Project: Proposed Residential Development off Pitt Street, Wombwell (2019/1117)

Title: Road Safety Audit (RSA1) – Designer's Response

STAGE 1 ROAD SAFETY AUDIT

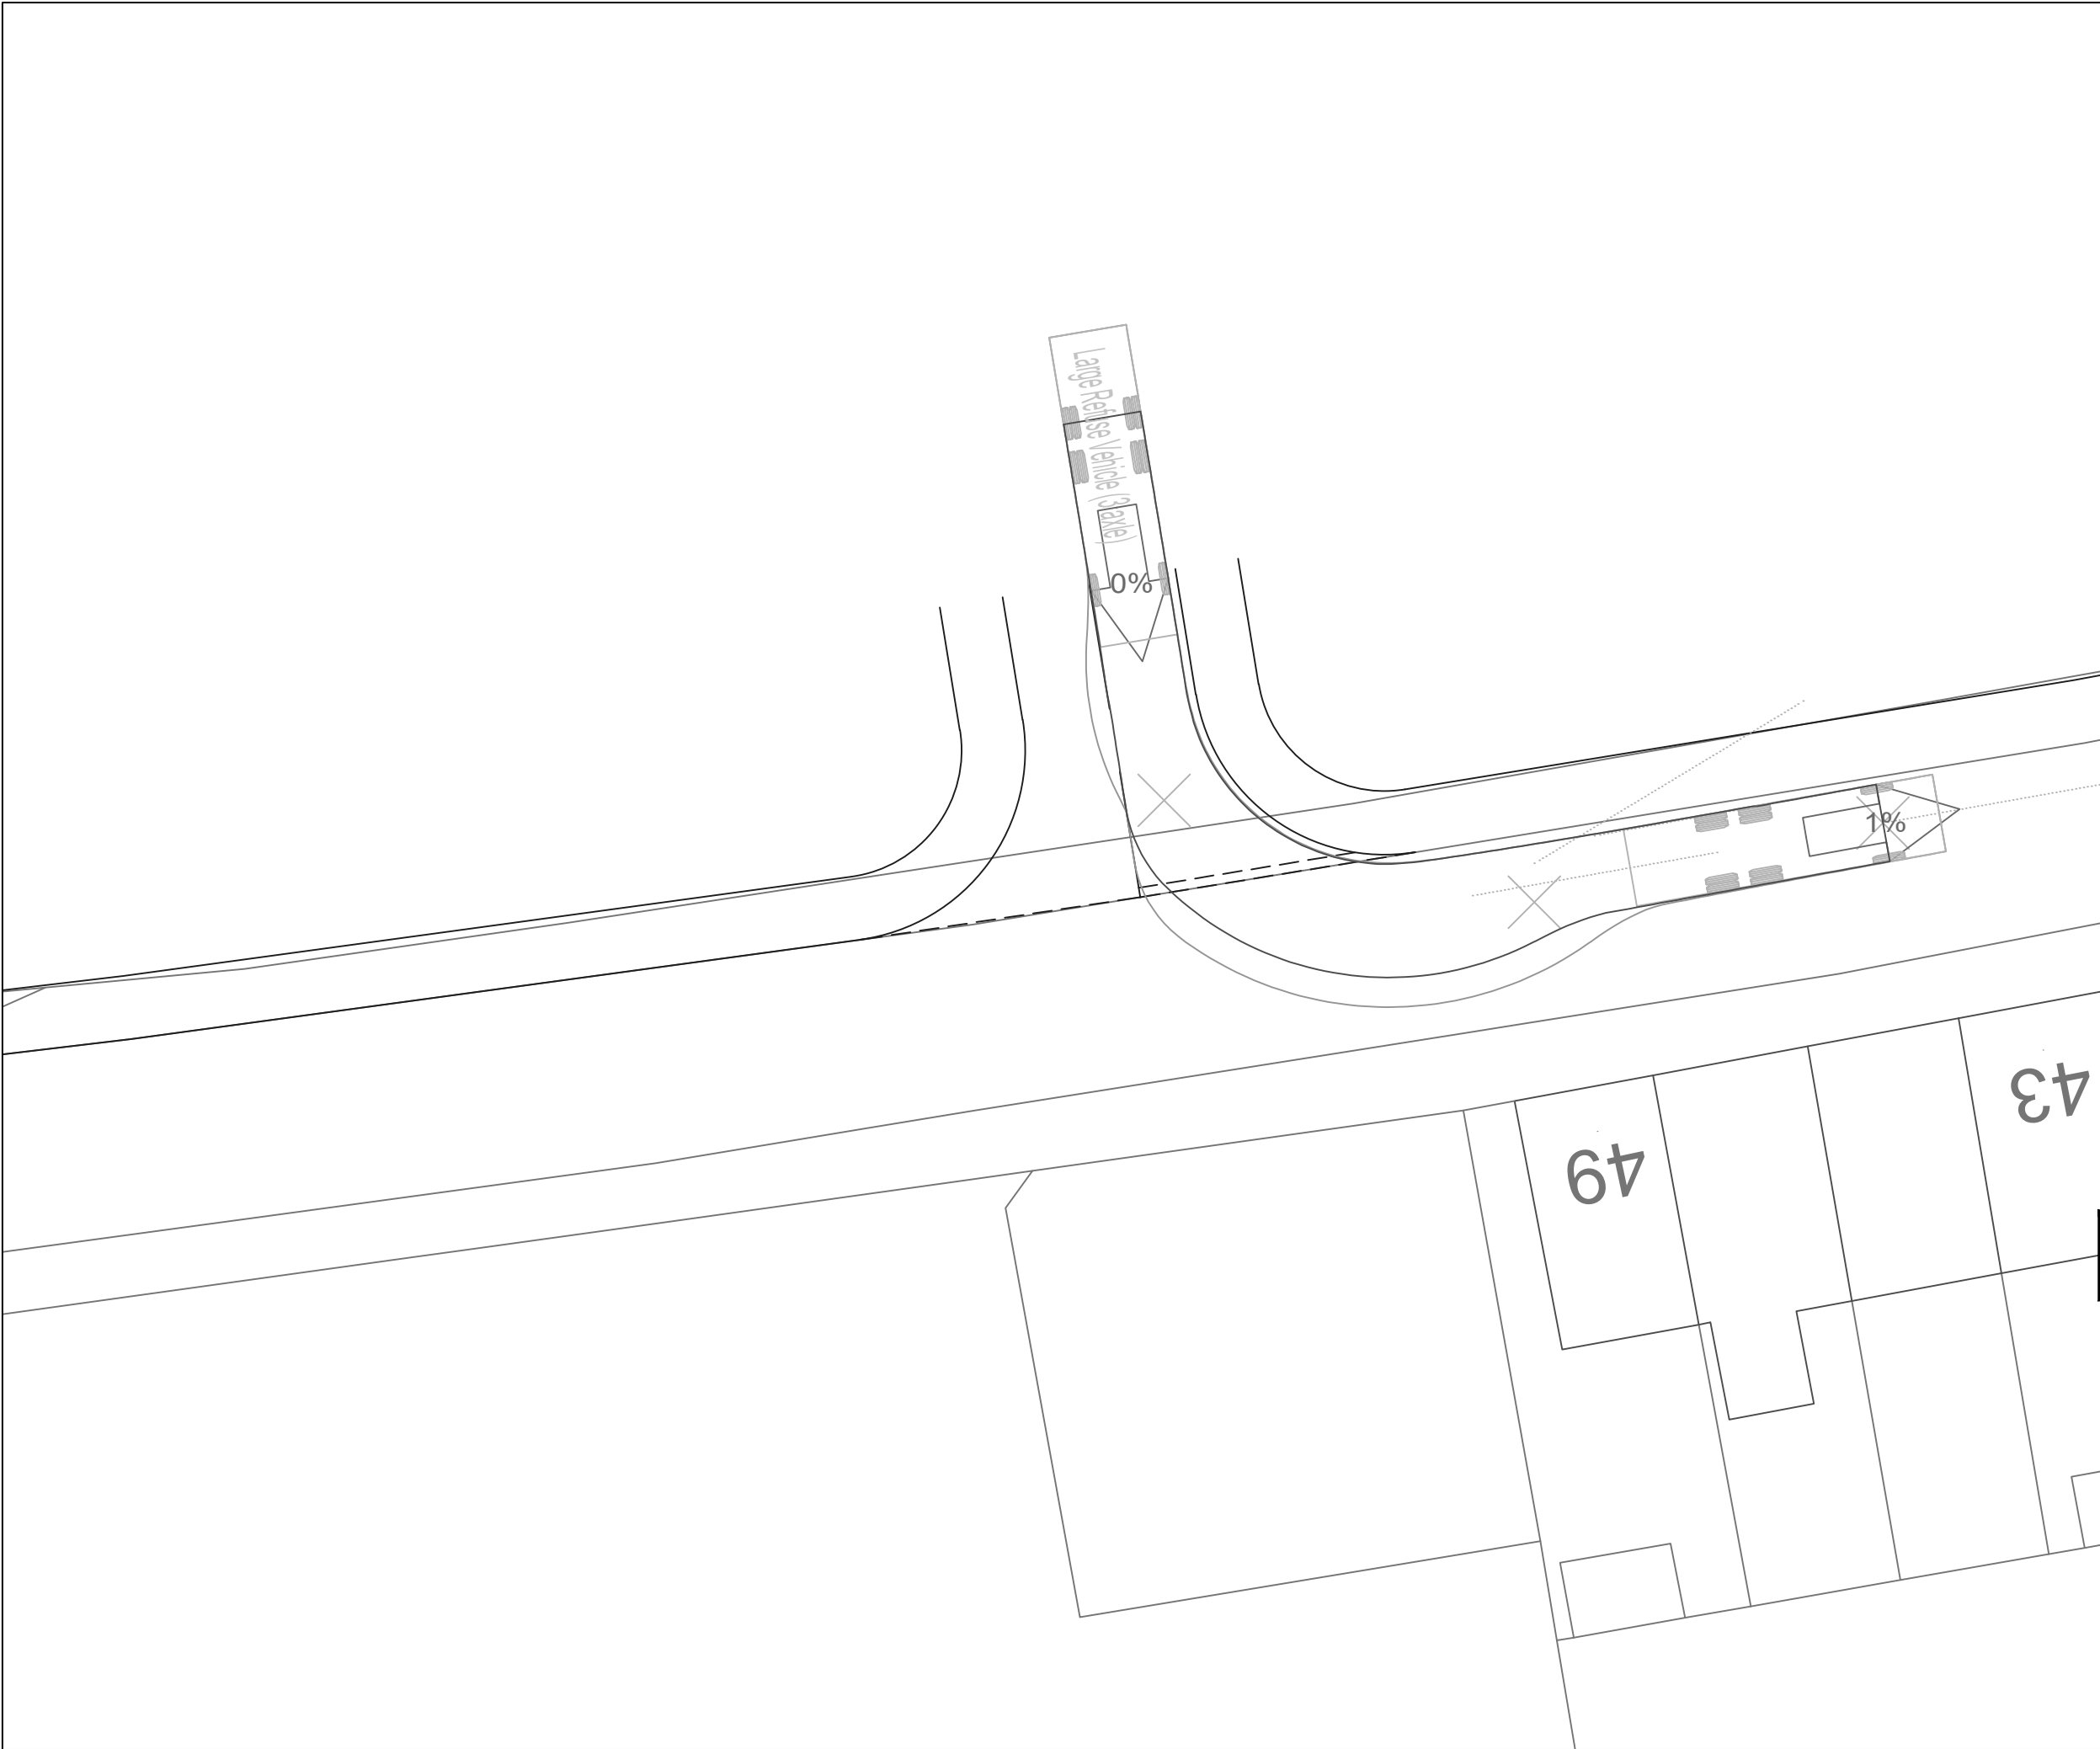
The proposed footway layout on both sides of the access junction does not appear to include pedestrian crossing facilities. There is a risk that pedestrians attempting to cross the new access junction would be forced to negotiate full height kerbs without the aid of tactile markers to guide them. This could lead to a risk of trips and falls and may pose a particular difficulty for pedestrians with sight impairment.

It is recommended that pedestrian crossing facilities inclusive of dropped kerbs and tactile paving be included in the detailed design of the new access junction.

The historical accident data close to the site indicates a cluster of accidents occurred in the five-year period between 2013 and 2017, a number of which resulted in serious injury and more than half of which involved children being struck by vehicles. Data submitted to the Audit Team suggests that the mean of the 85%ile surveyed speed is between 36 and 37 mph. Whilst the general design of the access junction layout appears to be broadly consistent with design guidance set out within Manual for Streets, the 85%ile speeds suggest that some vehicles may significantly exceed the speed limit. The cluster of accidents may support this. Consequently, it may be that the design – including visibility, etc - should be adequate for a higher speed. If drivers leaving the access do not see approaching vehicles, then they may pull out into live traffic, resulting in a side-on collision.

It is recommended either that the scheme is designed with parameters appropriate to a higher speed limit, or that measures are implemented to ensure that the speed of vehicles passing the access is such that the design operates safely.

- 2.3 The proposed access junction has been amended to include dropped kerbs and tactile paving at the access junction. The updated layout is attached as Appendix B.

- 3.4 The visibility required at the access has been calculated in line with the design guide method set out in Manual for Streets using speed survey data.
- 3.5 Notwithstanding the above, a review has been made of the visibility available and the splay adjusted to 78m based on the formula for 45mph design speed. This is shown in Appendix B.
- 3.6 The adjustment has been discussed with the auditor who has confirmed that this is satisfactory. Confirmation of this is attached as Appendix C.

- 3.7 To accommodate this visibility, all boundary treatments and/or landscaping within the splay will be maintained at a height below 600mm.
- 3.8 The width of Pitt Street limits the opportunities to introduce other design measures to reduce speeds at the access. However, the visibility splay has been increased as recommended.
